RFI

RFI #: 161
Date: 6/25/2012
Job: EB-02 Keller Springs Lofts
Phone: 877-777-5115

Subject: Electrical Outlets Moved for Code

**E-2.11**

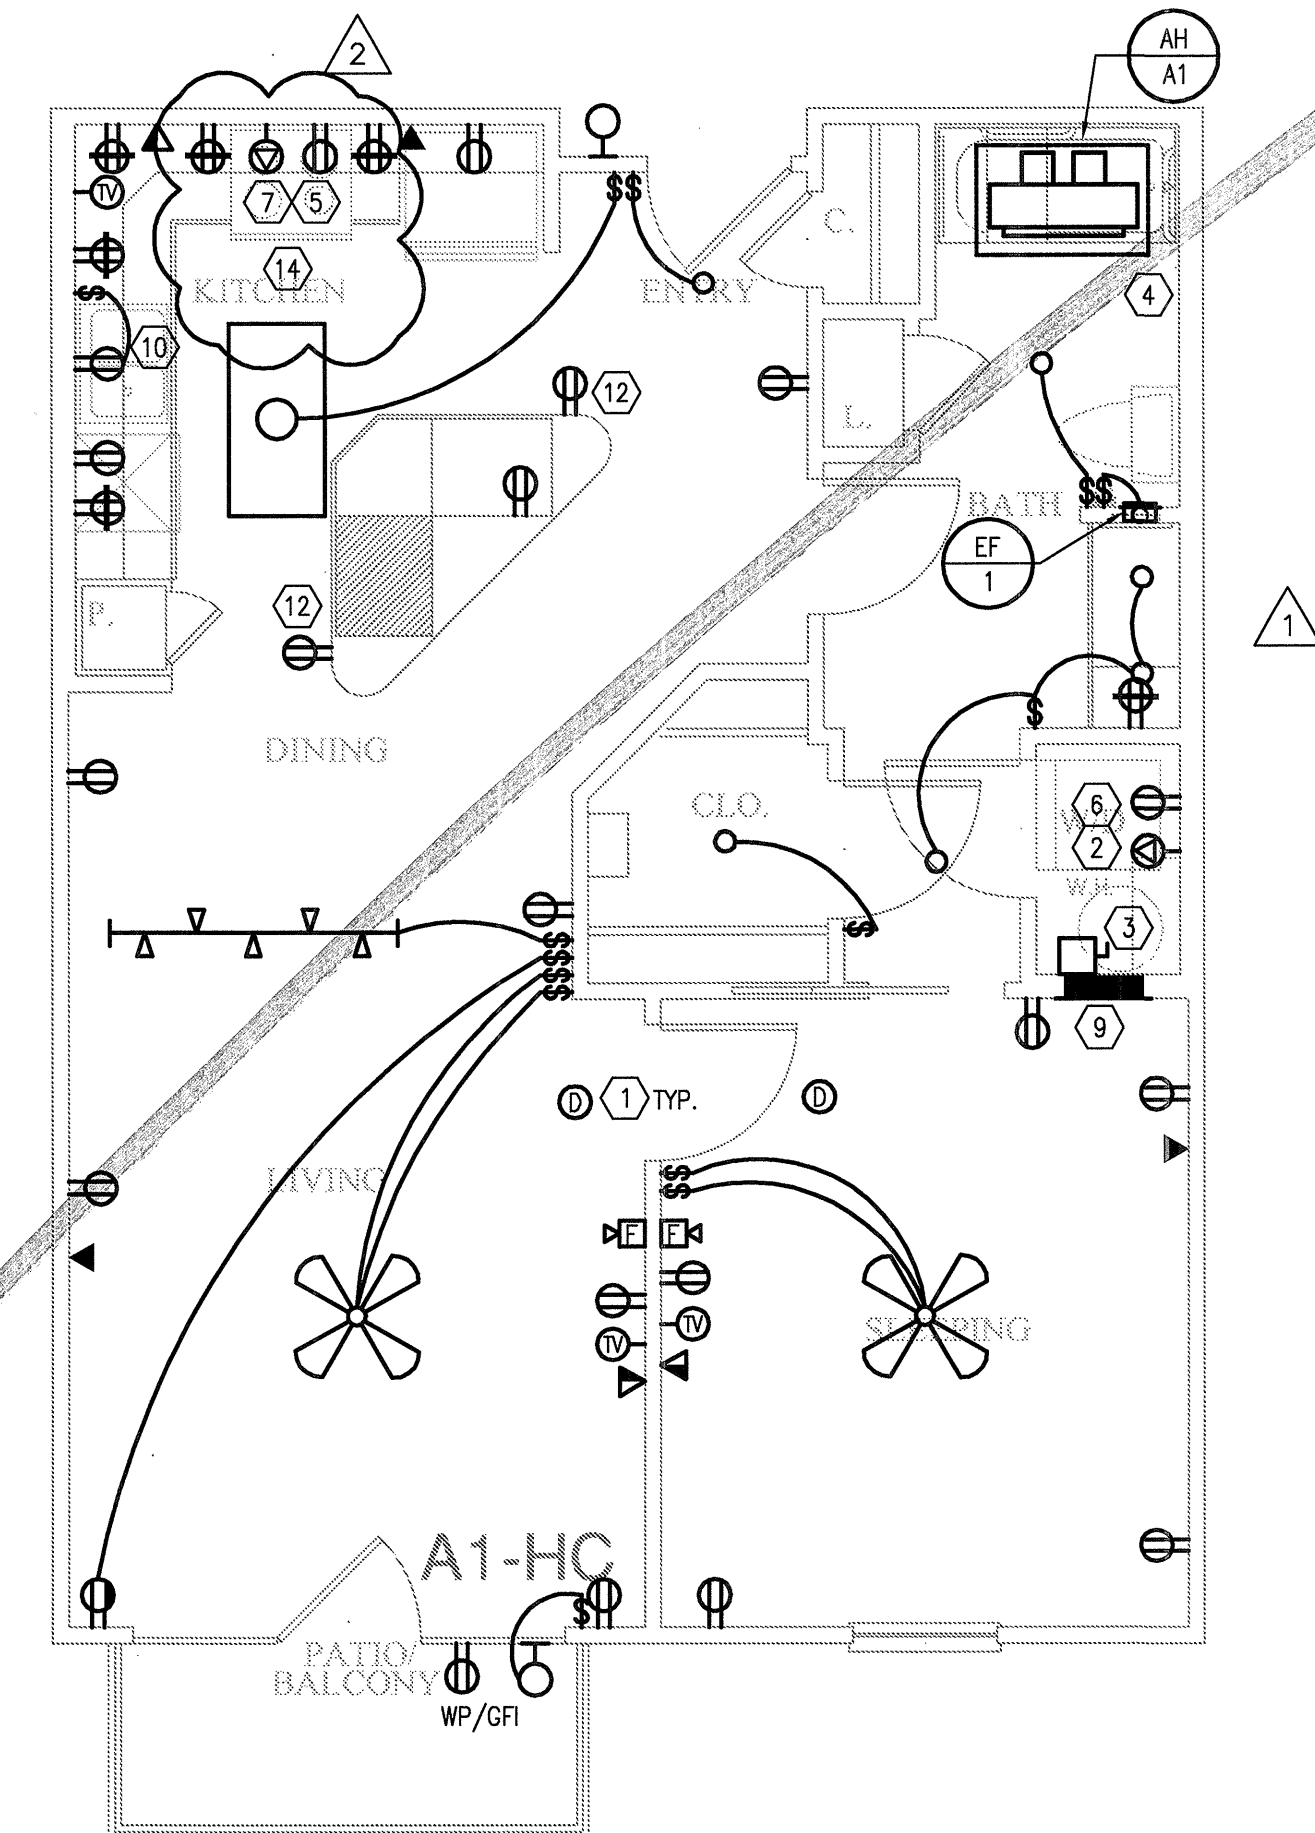
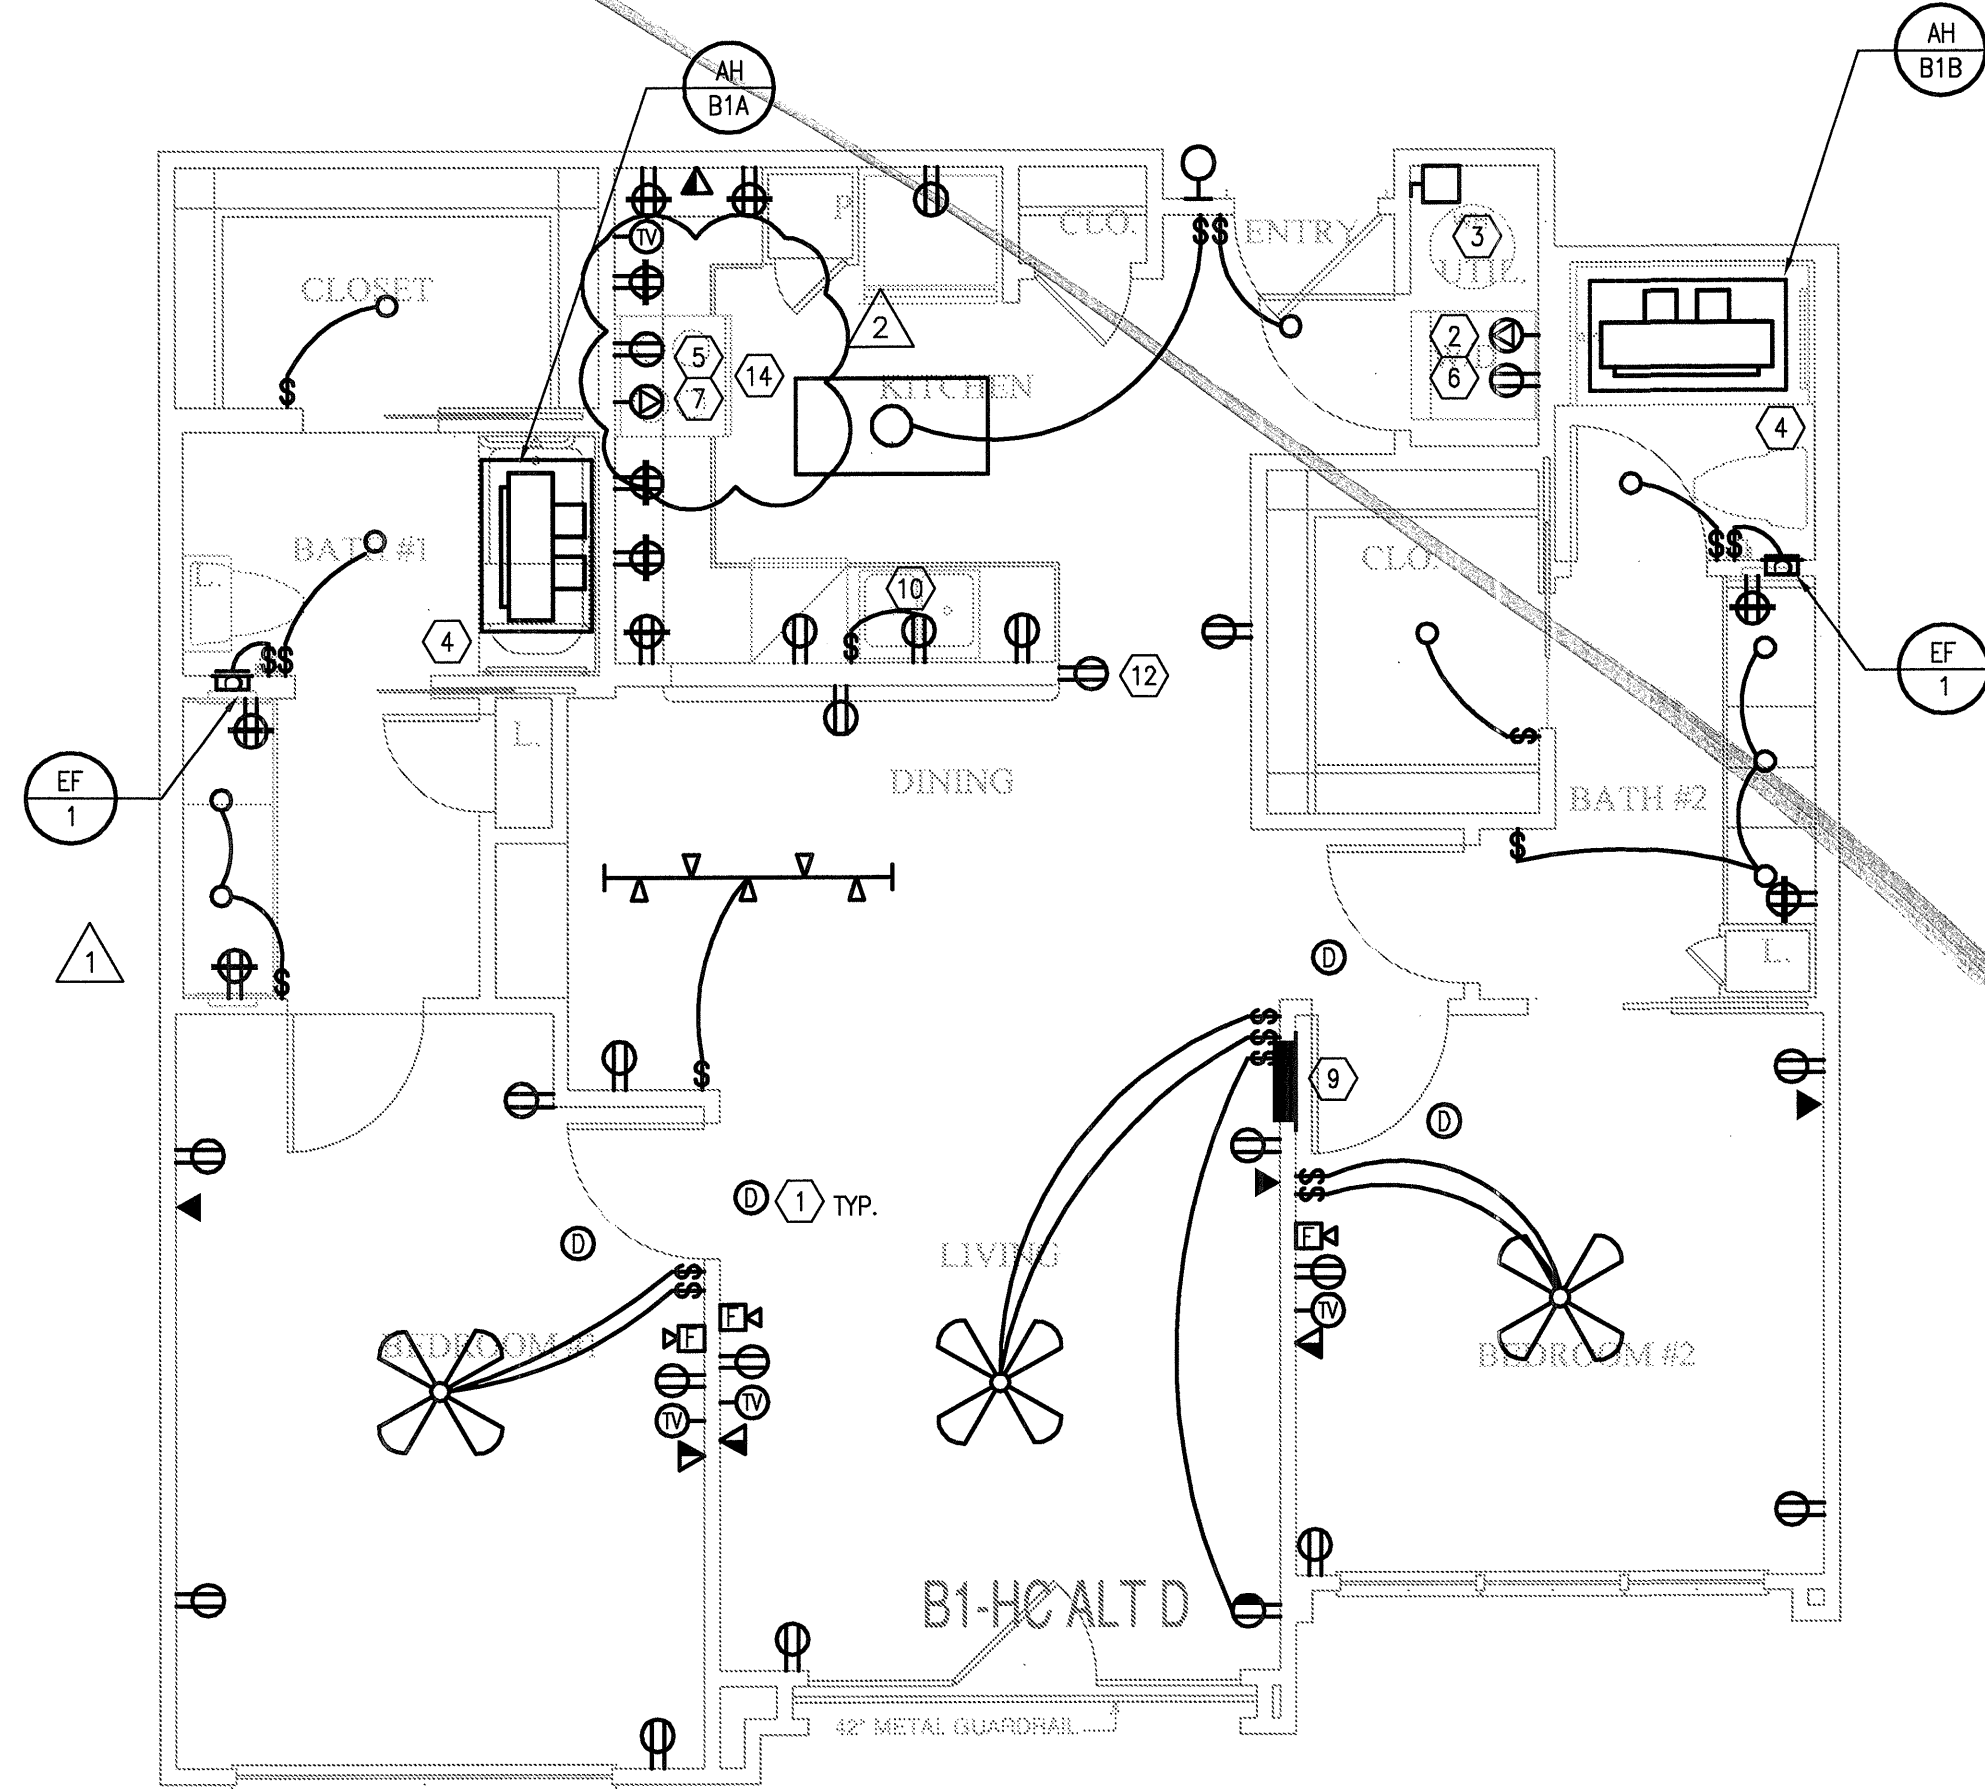
Request: We had an issue at another job where some receptacles needed to be moved in bathrooms due to code. Please check and see if this issue will need to be addressed at this job and revise plans if needed. **Date Required:** 6/26/2012

Reference the attached pdf's showing the correct outlet locations.
